To: [Department of Planning, Industry and Environment](#)
Prepared: Michele Zornitta (Associate Water Resources Engineer -WSP)
Approved: Rob Leslie (Section Executive – Water Resources - WSP)
Subject: **Waterloo Metro Quarter OSD**
SSD-10437 Southern Precinct – Response to submission comments
Date: 17 June 2021

Specifically, this note responds to the comments for the Southern Precinct detailed SSD DA (SSD-10437).

Status	Revision
AFT D&C Builder	N
Sheet number	Revision
WMQ-BLD3-BSA-AR-DRG-DA100	N

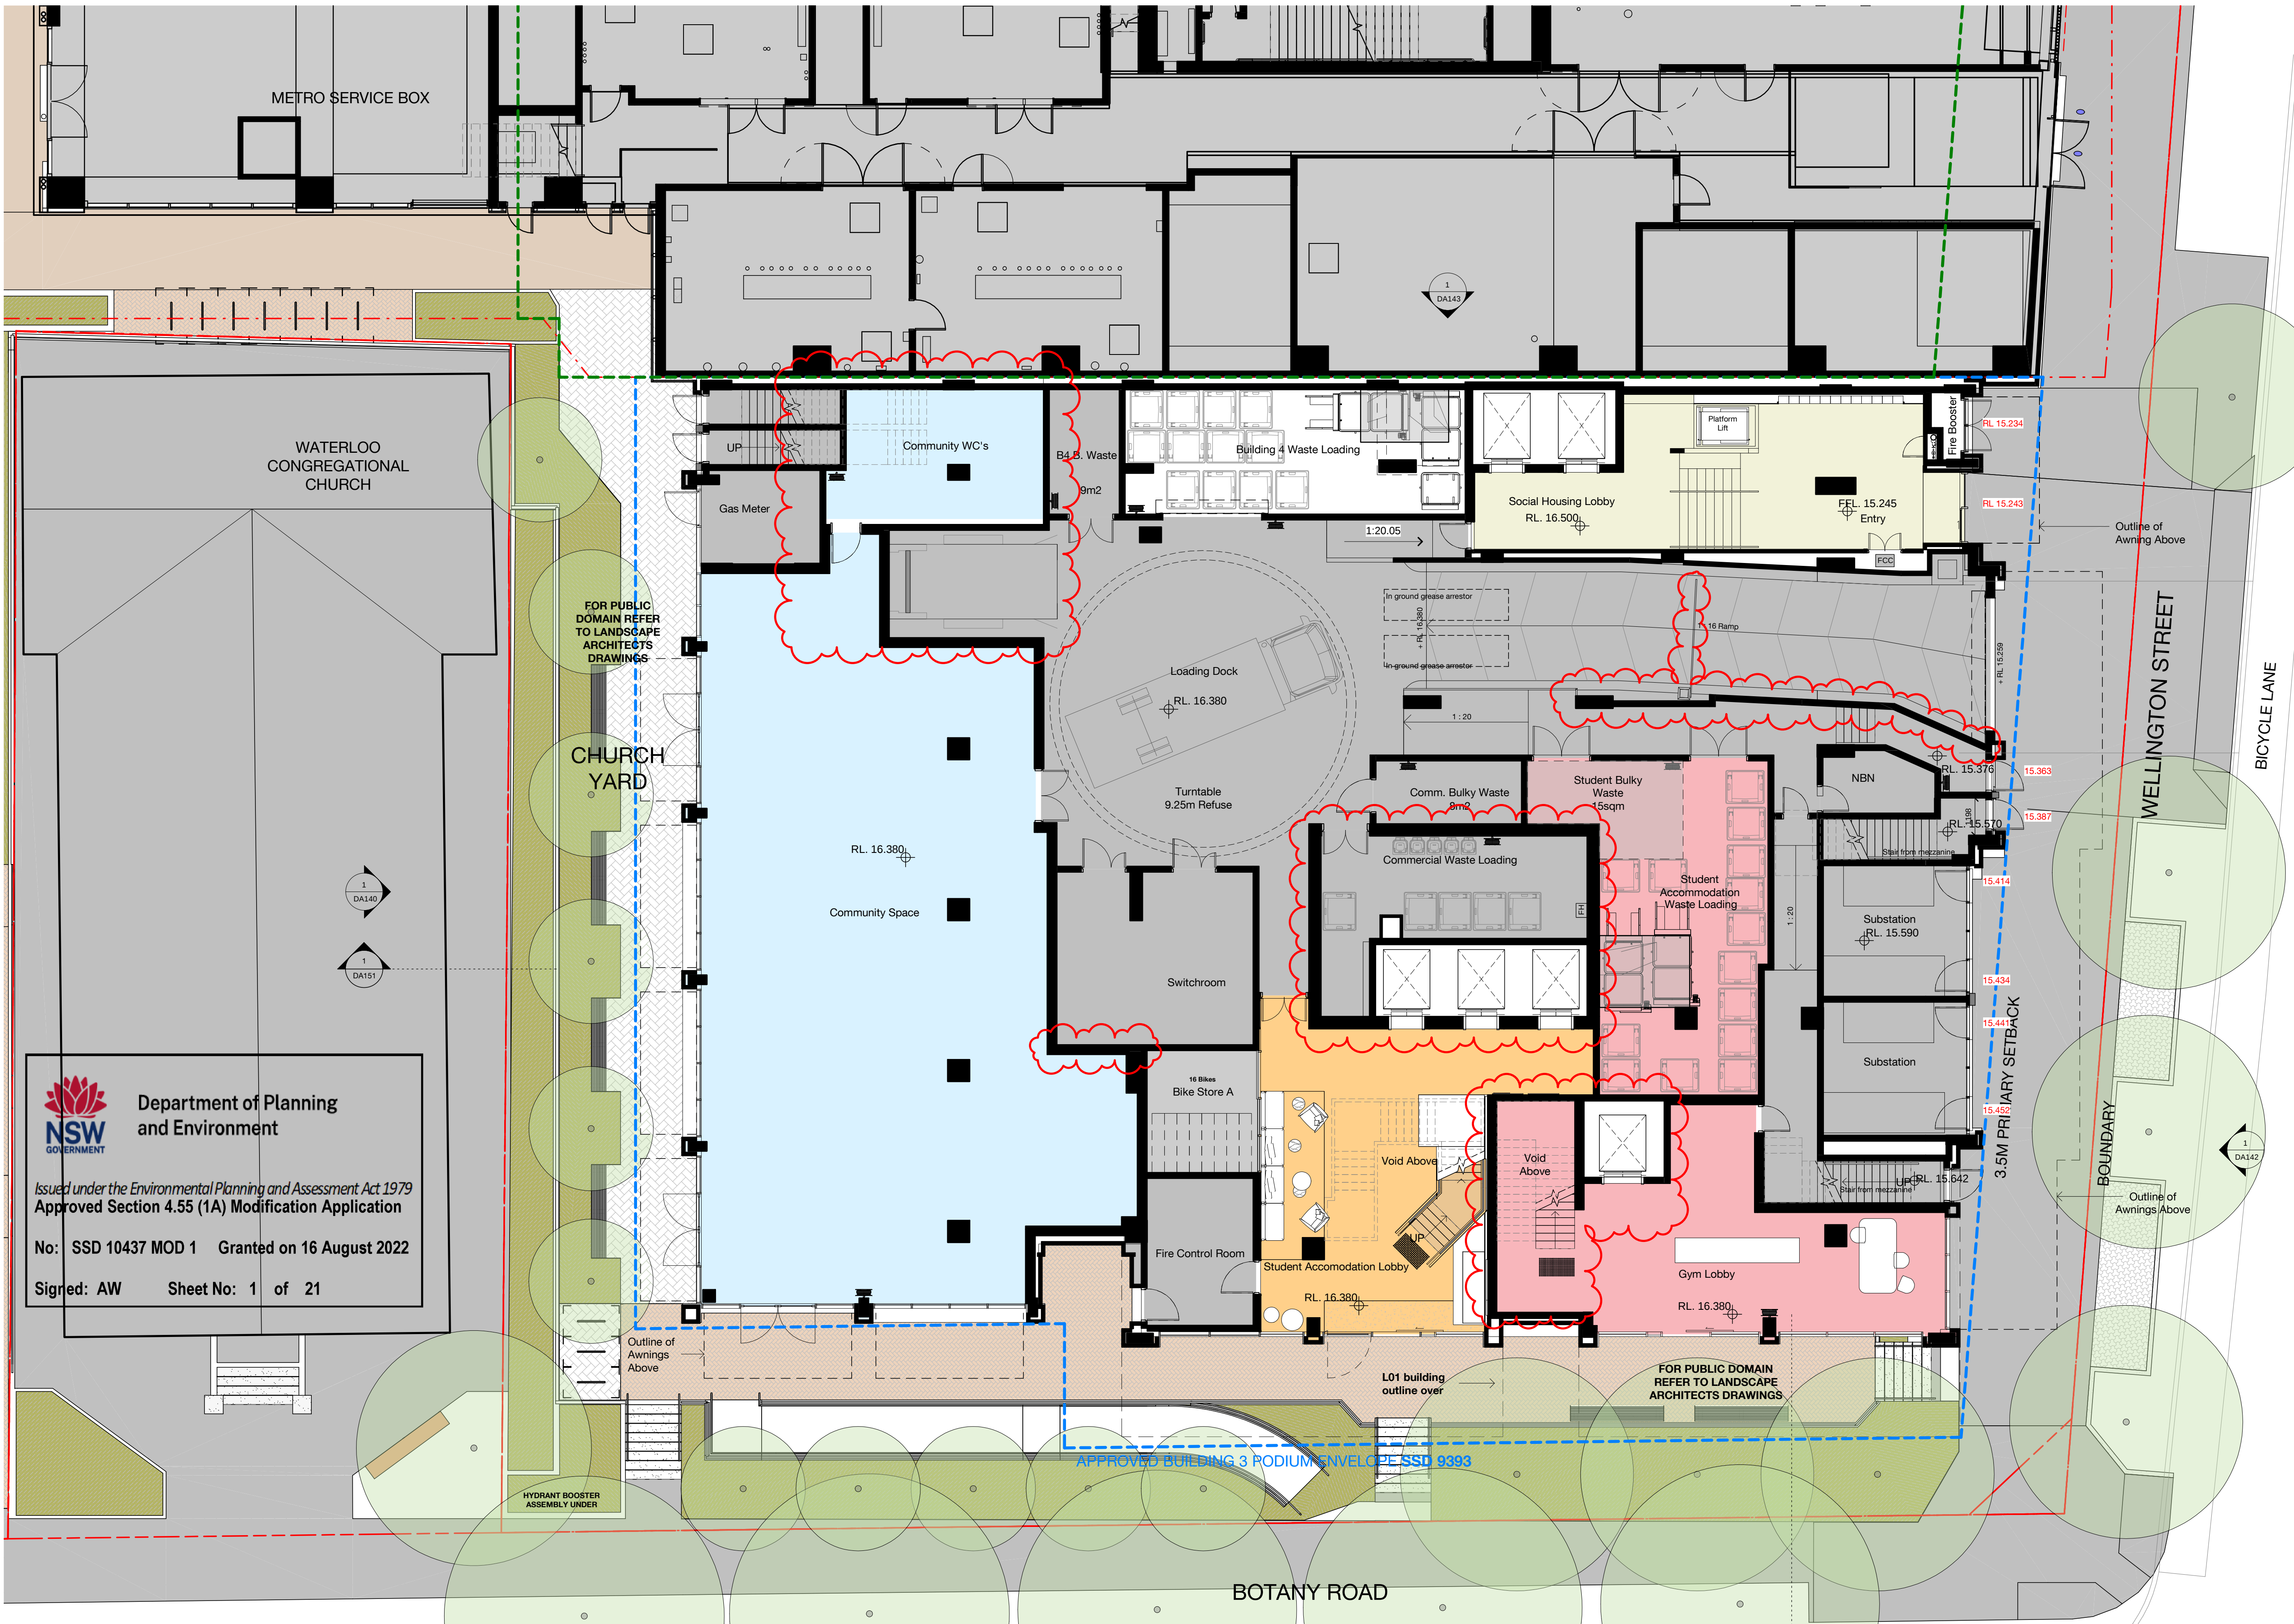
EES originally recommended that the proponent engage a suitably qualified and experienced professional to develop an appropriate strategy for flood emergency management. Neither a flood emergency management plan nor detailed emergency management procedures is required for this stage. However, a strategy is required to demonstrate that the current design allows risk to life to be managed. This includes calculation of persons and risk and consideration of suitable shelter in place. If the proponent does not investigate emergency management at this stage, the continuous flood risk may not be able to be properly managed later.

As noted by the EES reviewer a flood emergency management plan and a flood emergency strategy are not required at this stage. A preliminary flood emergency strategy is provided below. A flood emergency management plan will be prepared in accordance with planning conditions or relevant legislation at a later stage prior the occupancy of the building.

As requested by the EES reviewer further details that include the number of occupants of the building (at ground floor) and locations of the designated shelter areas are provided in this technical response.

An evacuation plan that shows the evacuation route to the shelter areas is included in Figure 2 and Appendix A.

- 1) Shelter areas that can be use as safe refuge are provided at ground and first floor (i.e. green areas in Figure 2, 3, and Appendix A);
- 2) Shelter areas have FFLs above the PMF flood level; and,
- 3) Safe evacuation routes have been provided from areas that have FFLs below the PMF flood level to the evacuation area with FFLs above PMF flood level.
